April 4, 2017

RE: 1210 BRIGHTON AVENUE  
REVISIONS TO HOTEL REDEVELOPMENT

We are pleased to provide revised plans for the above project. Portland Hotels, Inc. plans to start construction in May. During the final design process, several improvements to the plans were made which we believe need City approval. Below is a list of the plan revisions.

5 RIP-RAP PLUNGE POOL DETAIL  
C4.5 NOT TO SCALE

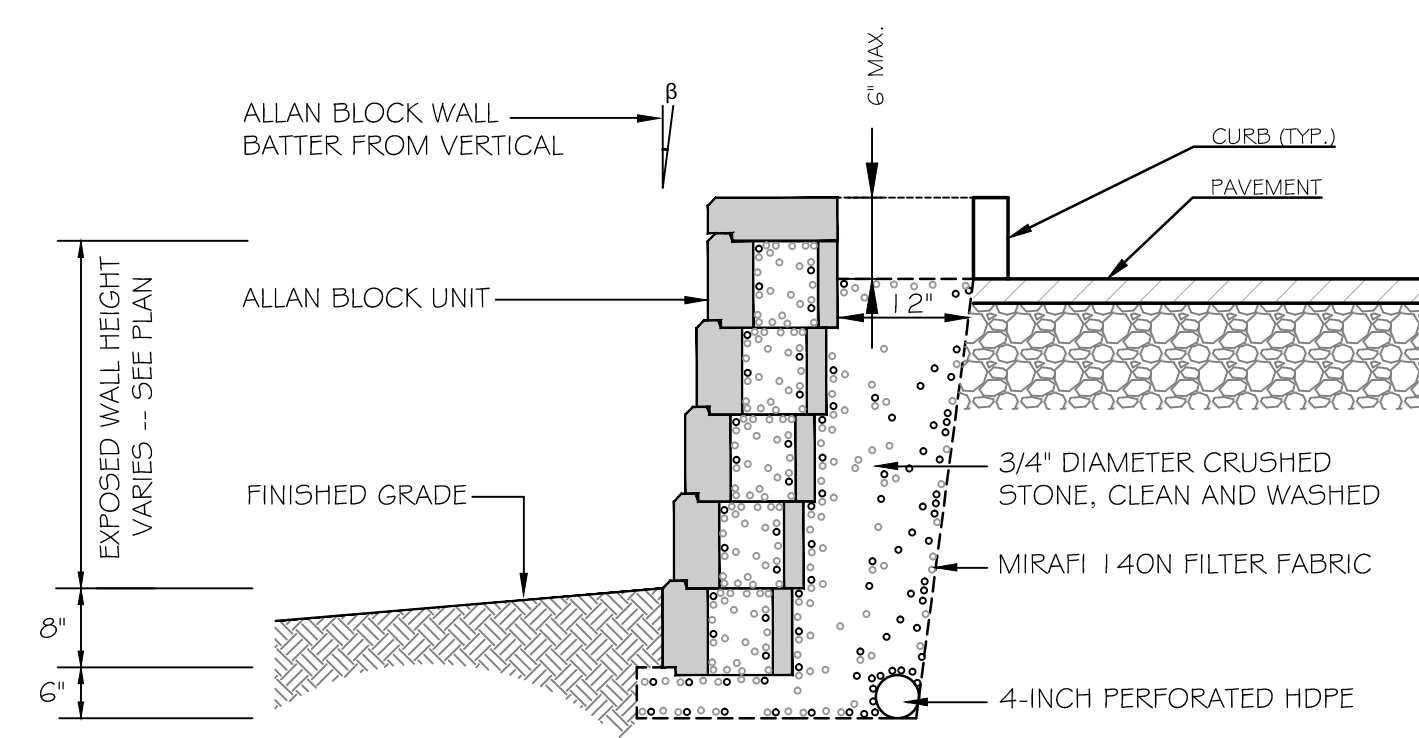
Attached are photographs of the area of AP#2 discharge. We are detailing the plunge pool on sheet C7.6 for the discharge. The water is currently going in that direction and will continue to in the developed condition. The outfall will be stable.
